Summary of the attached document titled "GNRSBP Reg. [REDACTED] Communication to PINS," authored by John Gray (PINS ID [REDACTED]), dated 10 December 2025.

From: John Gray, PINS ID number [REDACTED], PINS Case Reference: EN010162  
To: Planning Inspectorate  
Date: 10 December 2025  
Subject: Recreation Changes in Bathley and North Muskham  
(Community Orchard, Permissive Footpath 3)

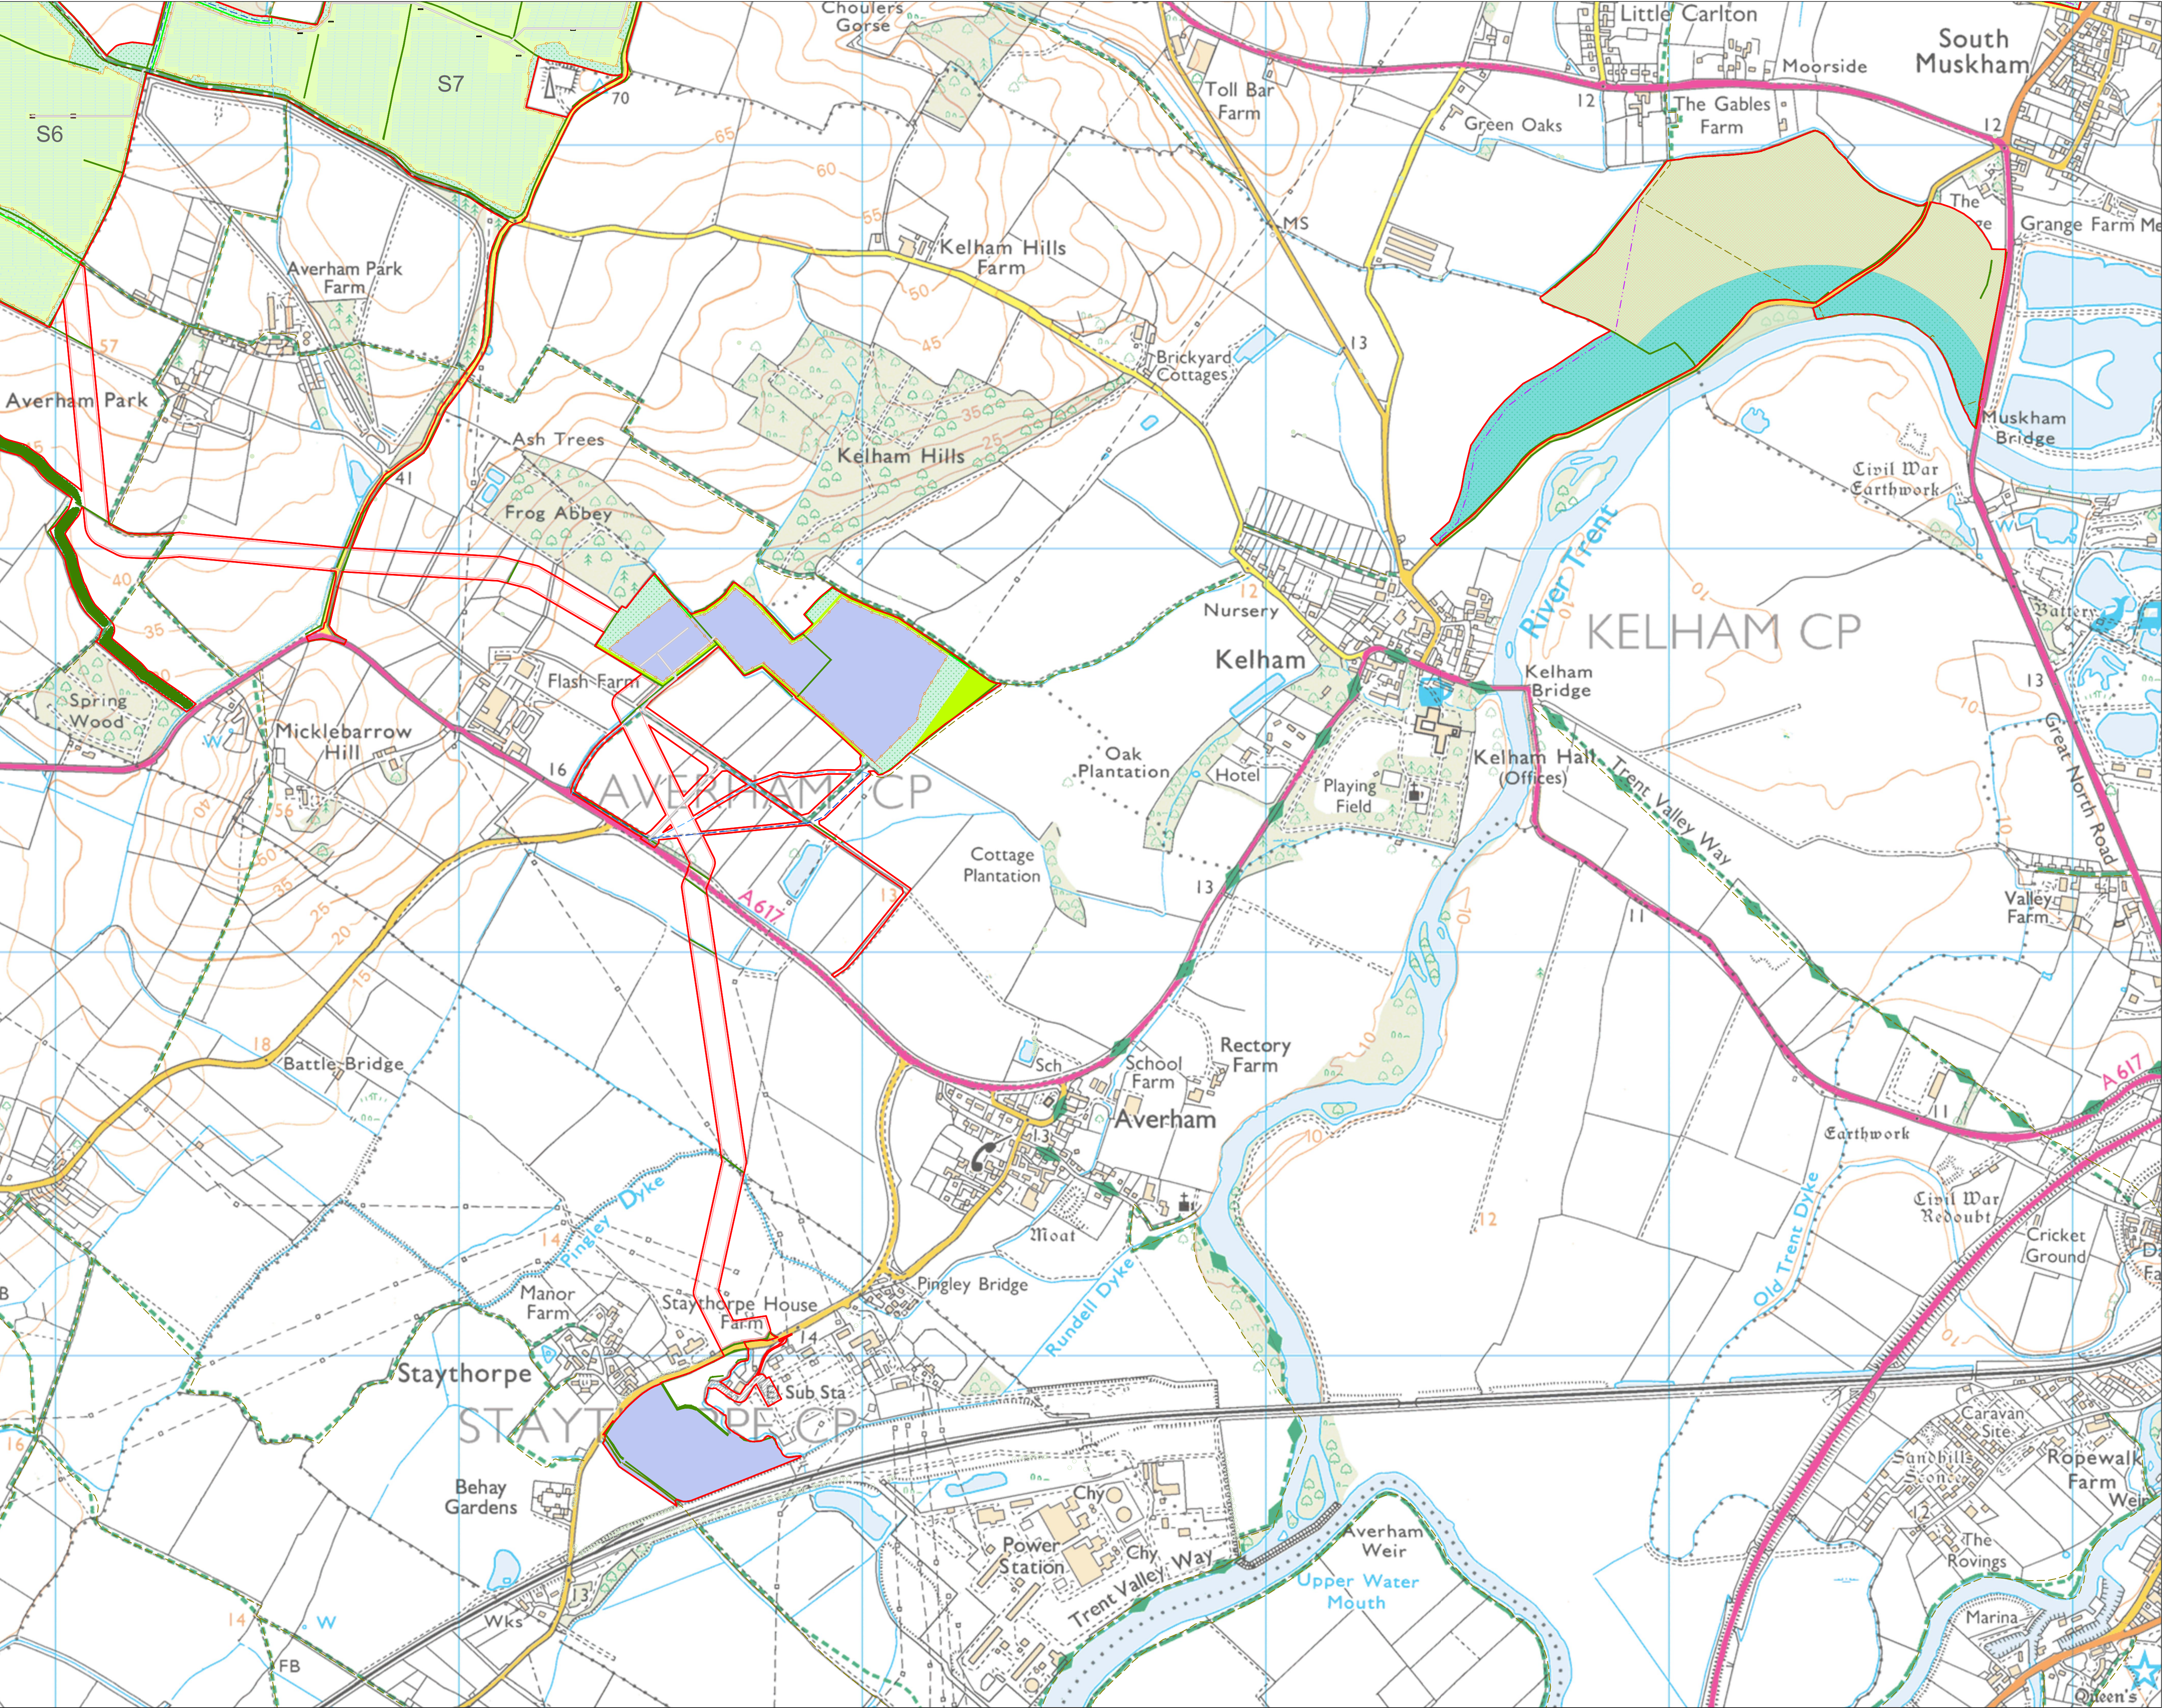
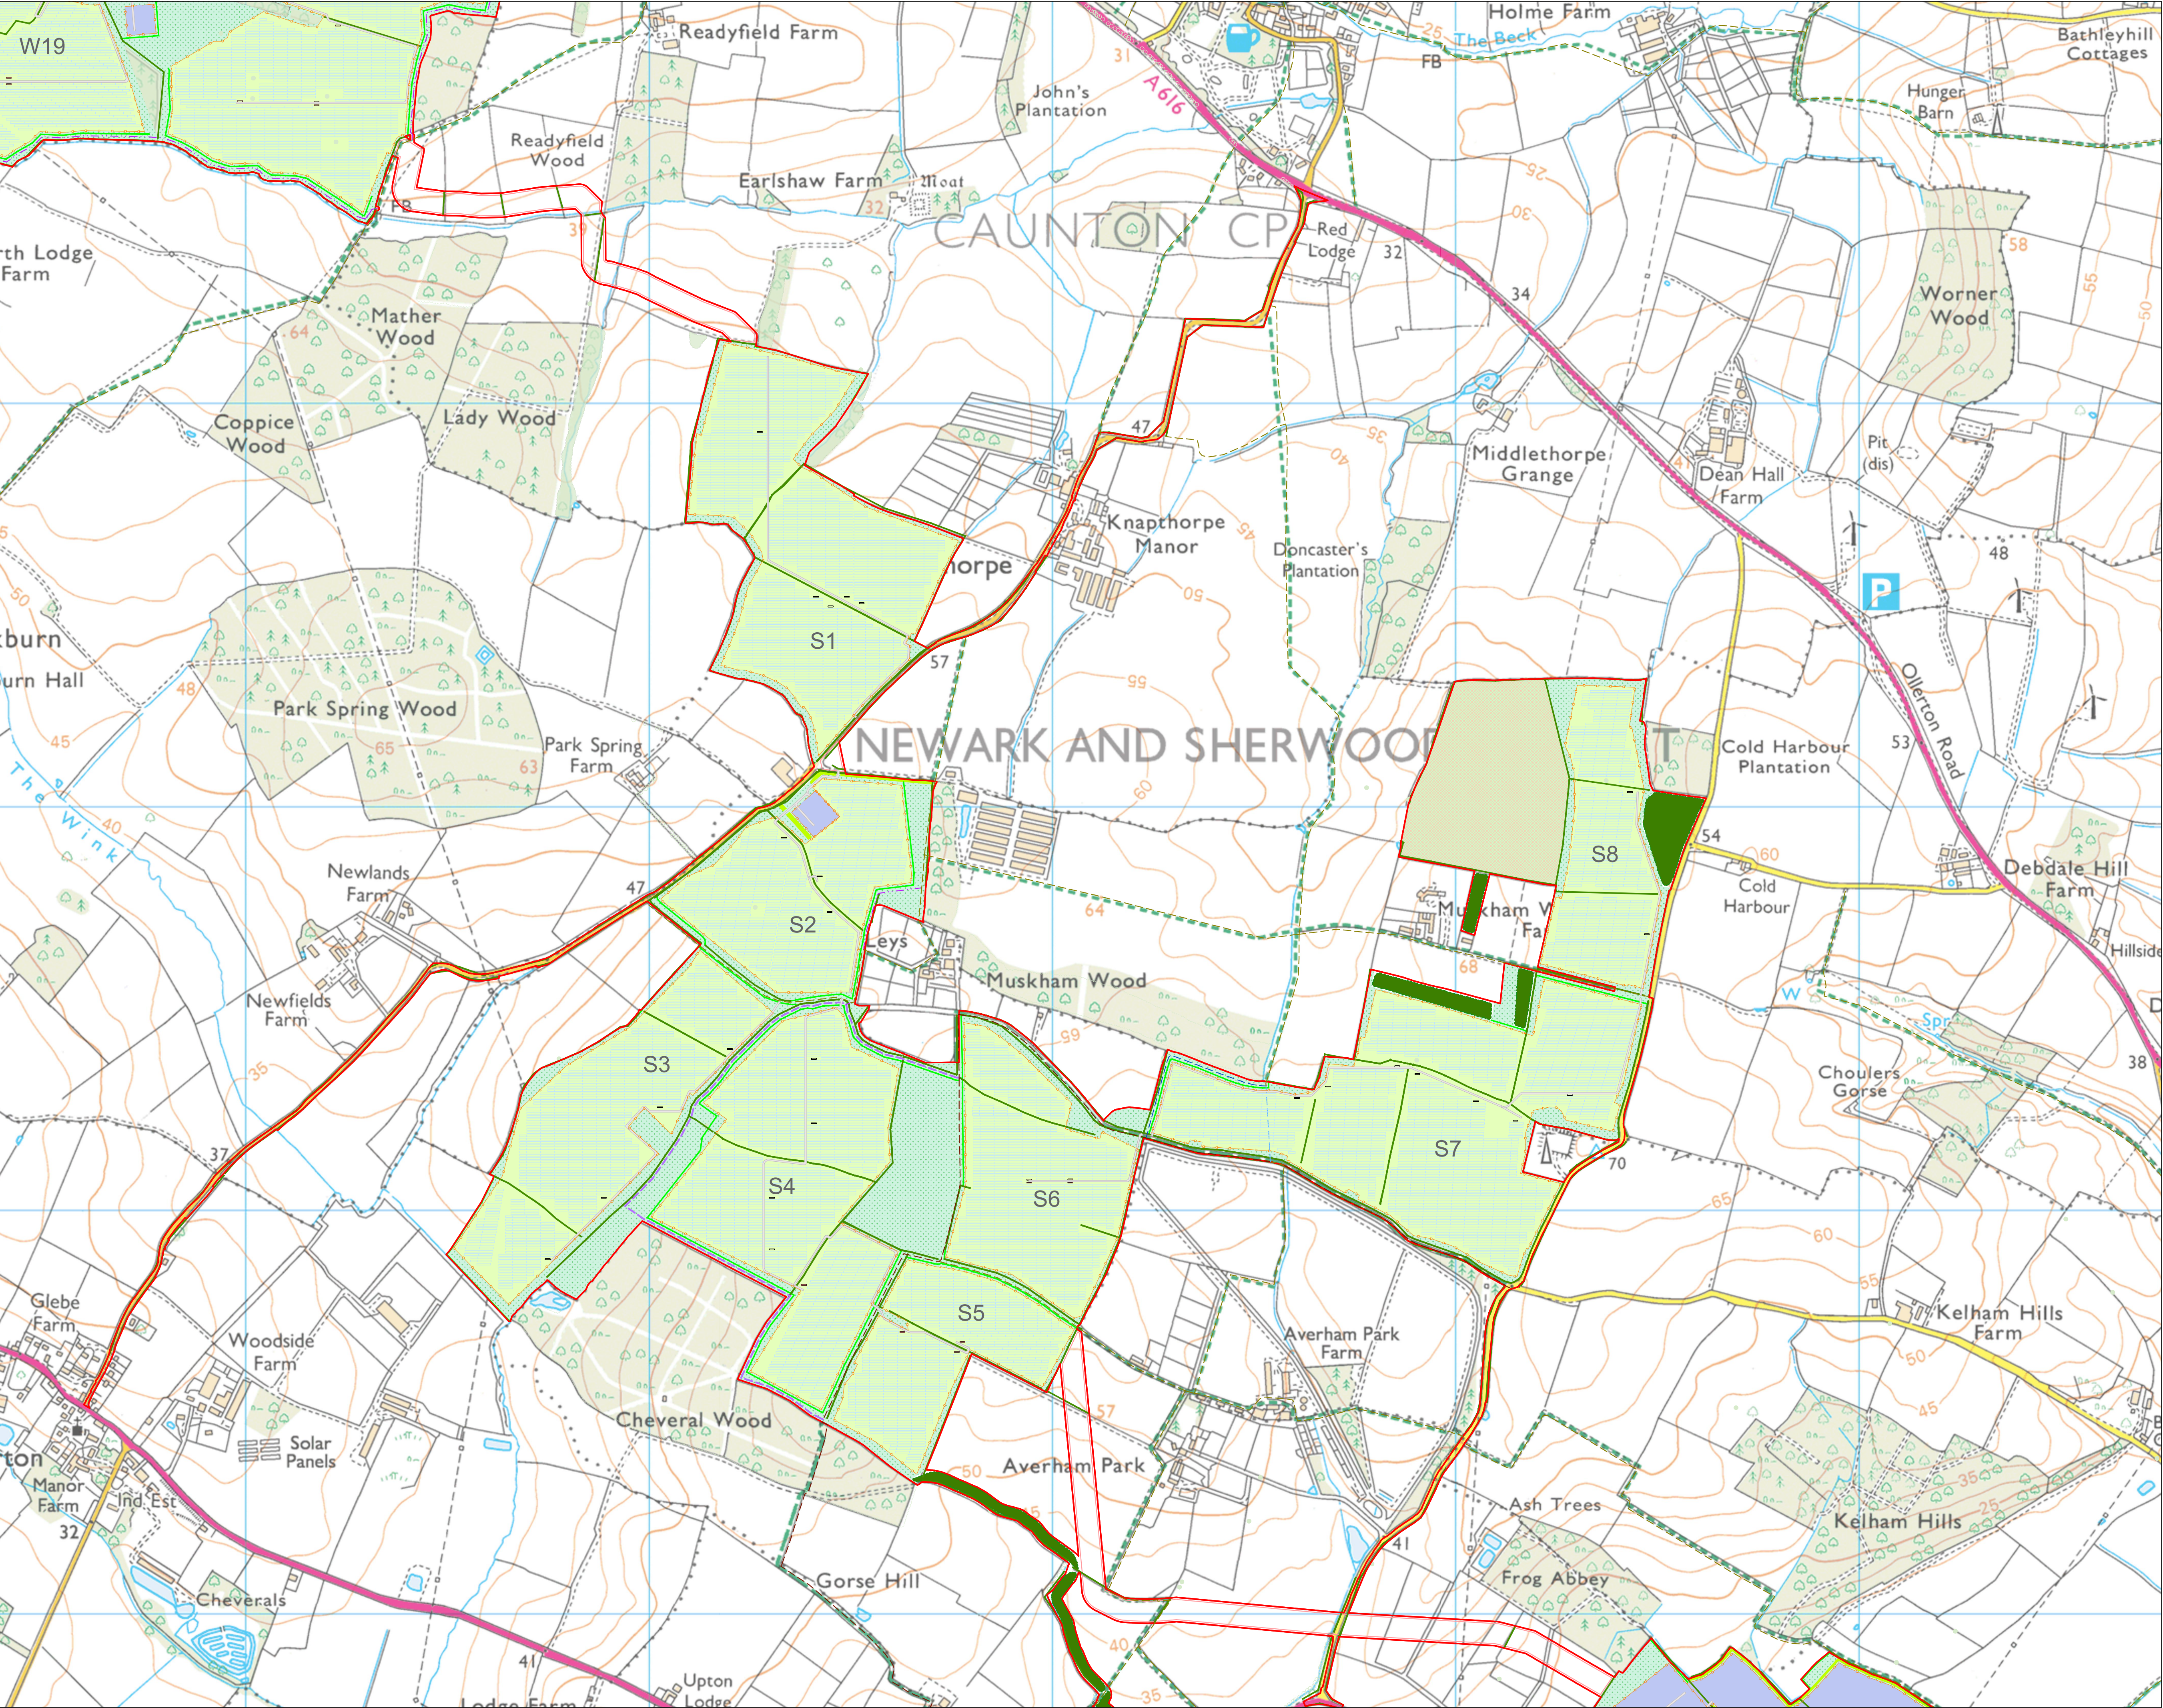
Figure 2 below is the most detailed 'plan' of the orchard I have been able to find in the APP documents [this level of detail occurs in many maps, I've taken this from APP-040,p.8], and added to it internal subdivisions and areas in the OL boundary.

- i. Is there a full plan and design document, with detailed proposals, in existence? If not, when will there be one available?
- ii. The applicant says *"The orchard is accessible via PRow."* [APP-061,p.46]. Where do the actual boundaries of the Community Orchard lie? The current route of Bathley Footpath 8 [NCC Footpath Modification] is shown as within the Order Limit, but is it considered as within the Community Orchard boundary? If so, will there be fences/stiles controlling public access? Or even *"gated and closed at night"* as talked of in Maplebeck [APP-061,p.17]?
- iii. Who owns the Community Orchard and the land it is to be developed on? Which organisation/business is expected to manage the orchard on a day-to-day basis, during construction and thereafter?
